Final Acceptance (FA) Punchlist from EPC Stormwater

Project Name:	Settlers Ranch F2C
PCD Filing Number:	SF1818, CON1929
ESQ #:	ESQ1925
Attendees:	DPW: Ben Jones, Natasha Grimaldo, Molly Layshock PCD: Brad Walters, David Parkerson Developer: Mark Davis
Date of Walk-Thru:	10/24/2022
Walk-Thru #:	FA Walk #1

SHEET: **C1.12C**

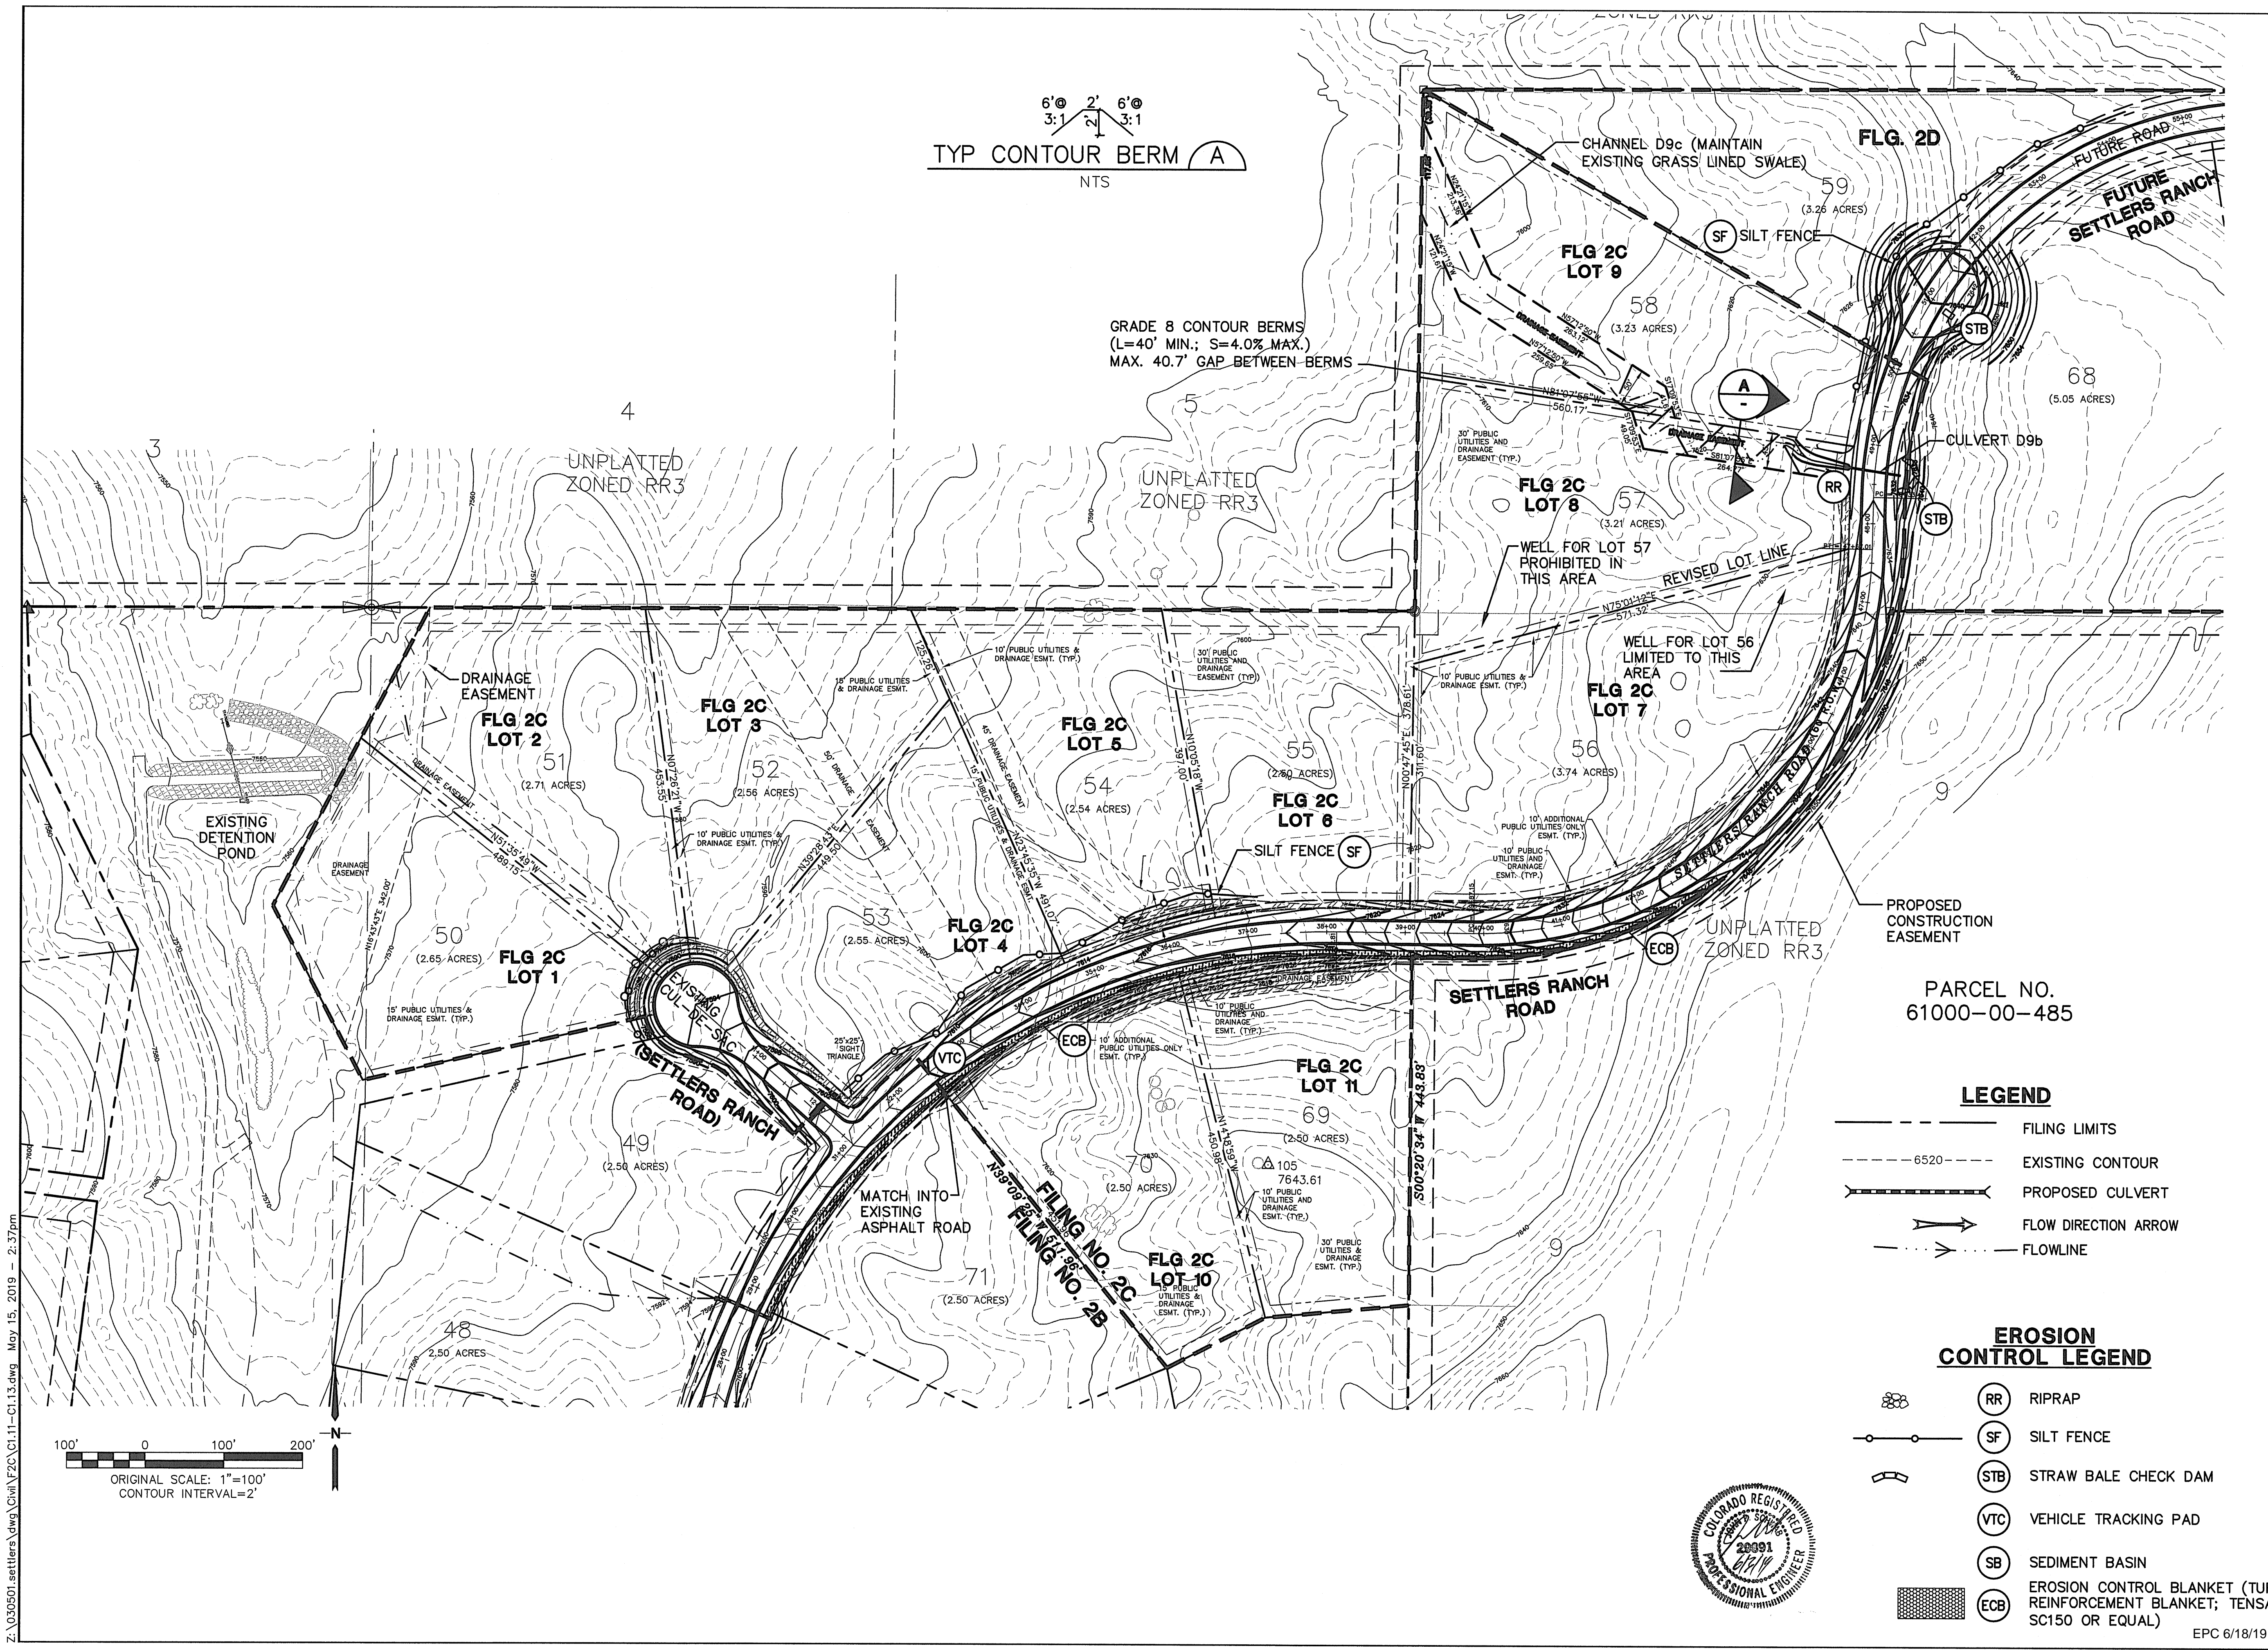
- Have JPS provide clarification regarding grading & contour berms (L=40' minimum; S=4.0% max with max 40.7' gap in between berms (Sheet C1.12C of CDs) at drainage easement between lots 8 & 9

SHEET: PP4C

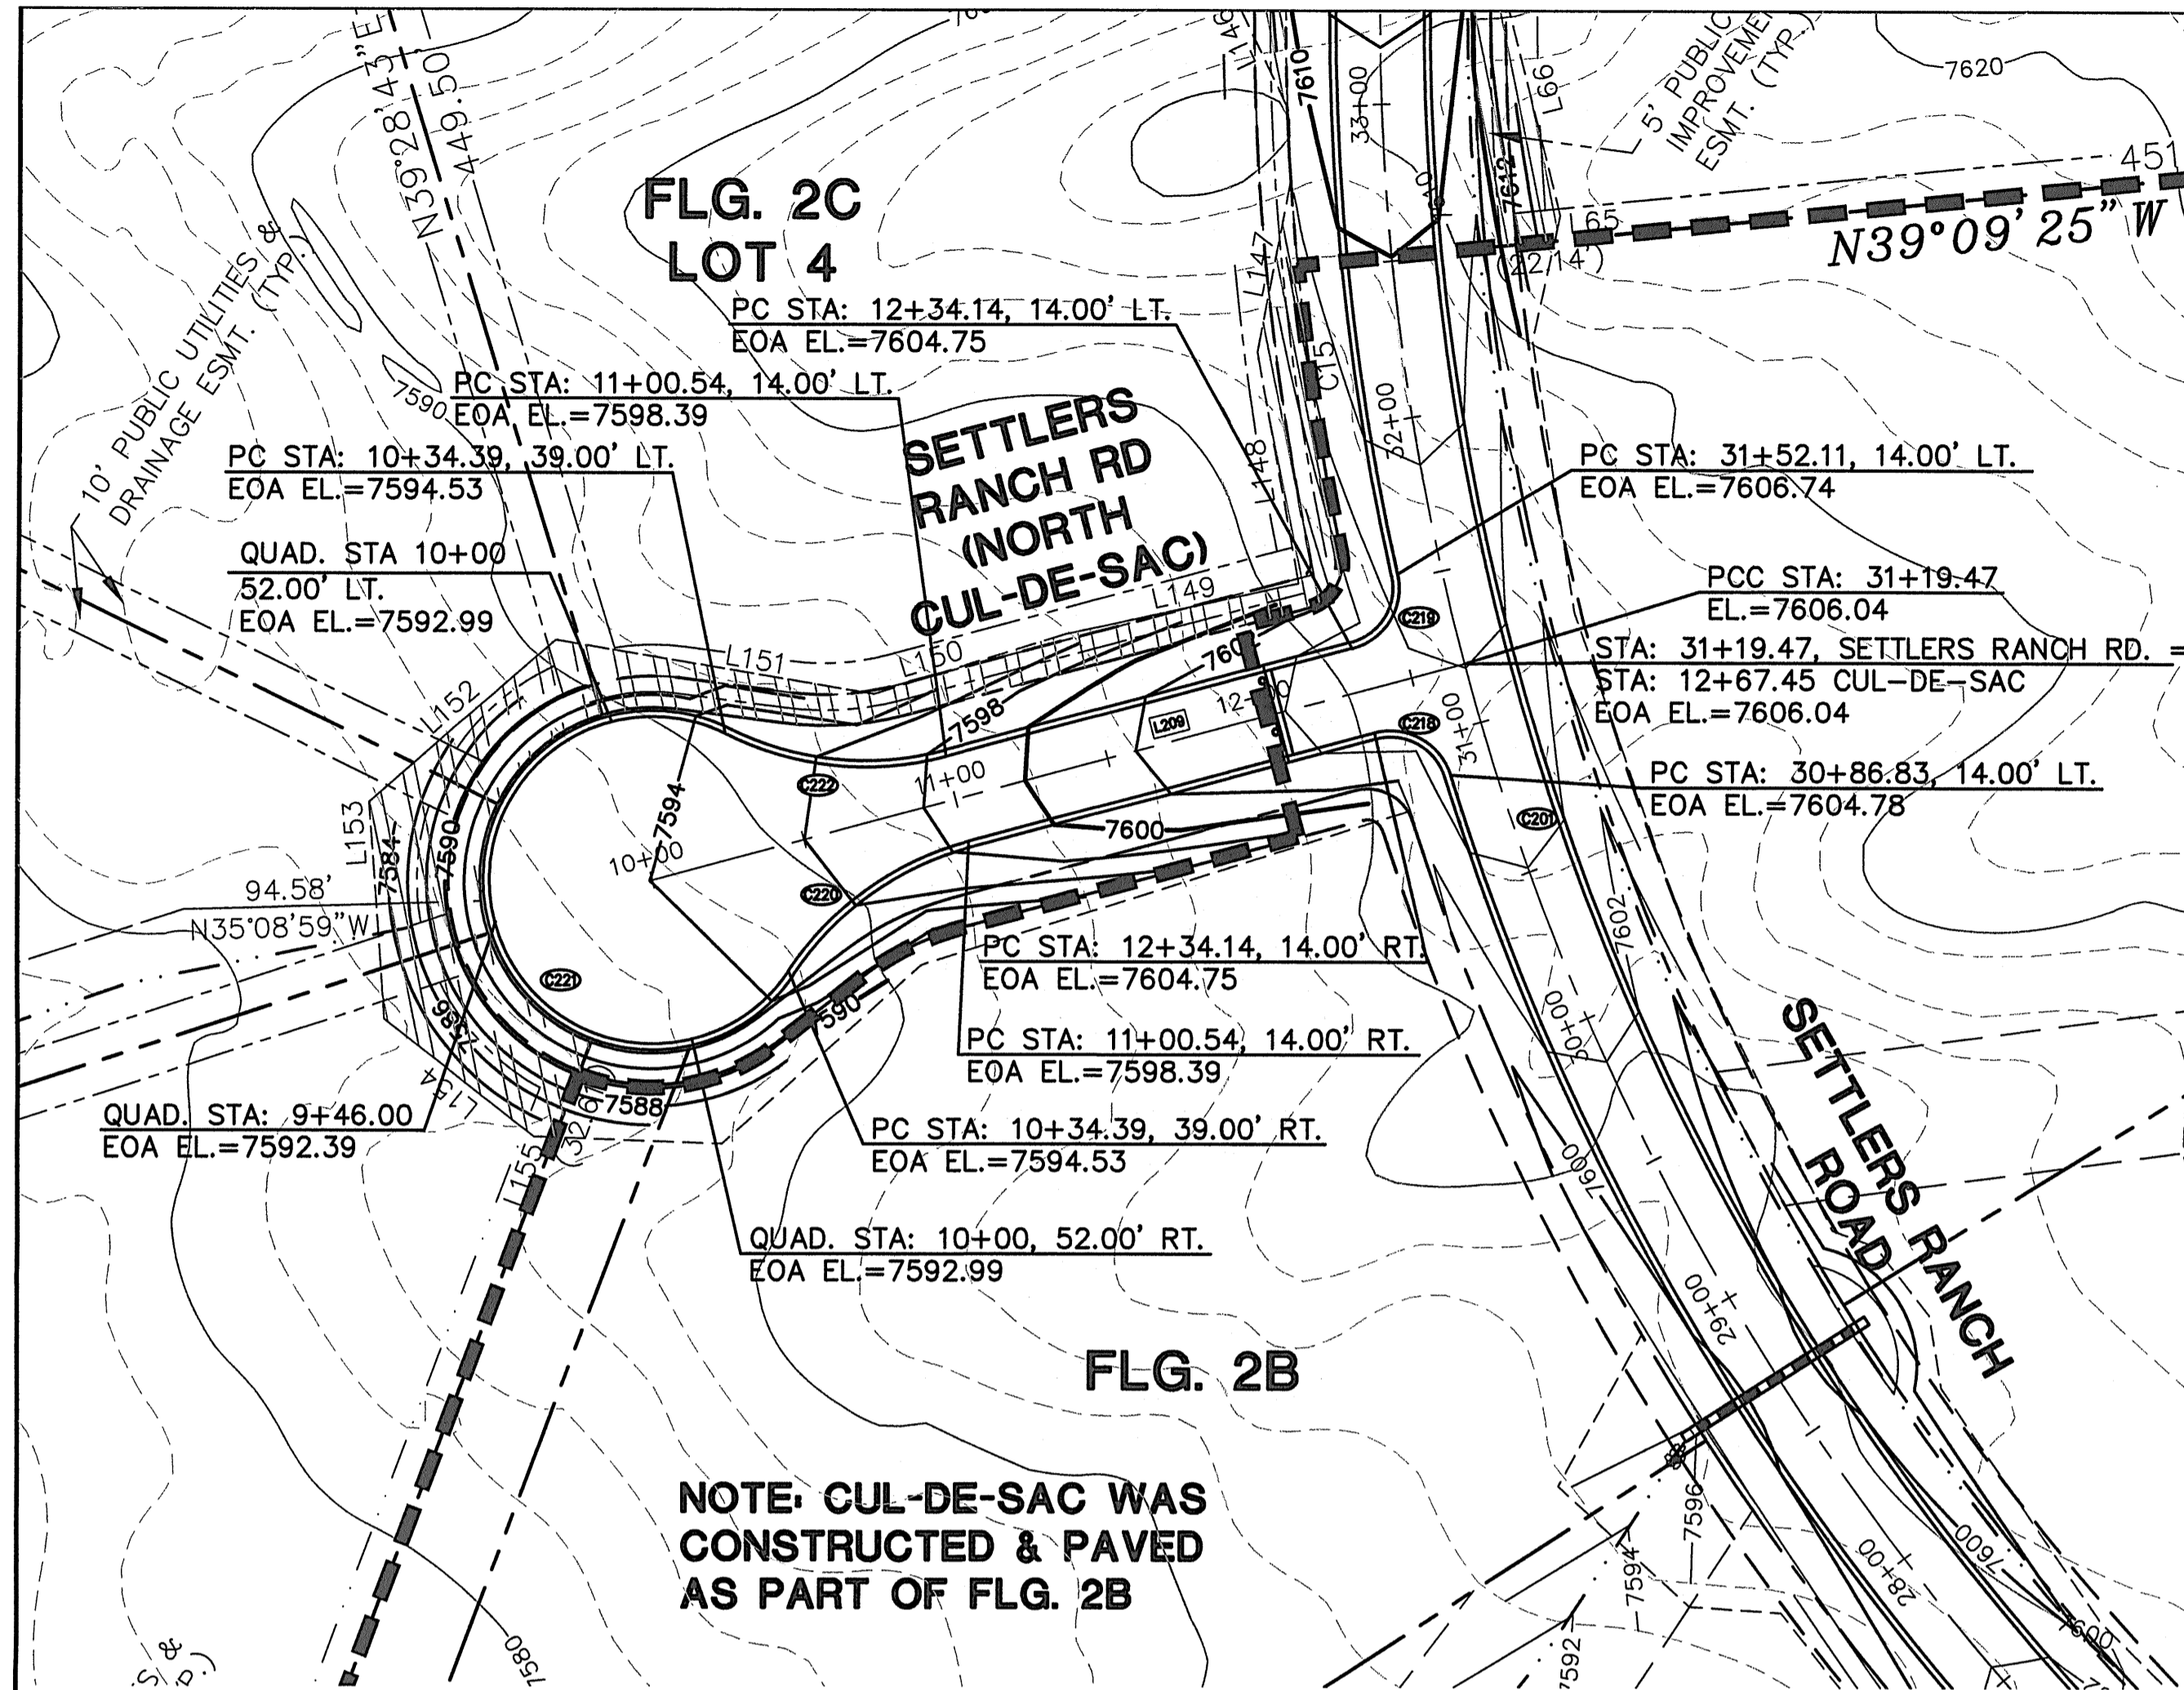
Culvert D9b (Sheet PP4C and C1.12C of CDs):

- Add 12-inch rock as per plans along downgradient side of culvert D9b along drainage easement (Photo 1)
- Remove sediment and all invasive weeds from riprap in channel at culvert D9b along drainage easement
- Culvert D9b needs to be field fit with sufficient grading and armoring on upgradient side where straw bale barrier was removed to ensure positive drainage into culvert across Settlers Ranch Rd (Photo 2) and to prevent erosion. Consult with JPS on an acceptable solution (riprap sizing for example). Add solution to as-builts.
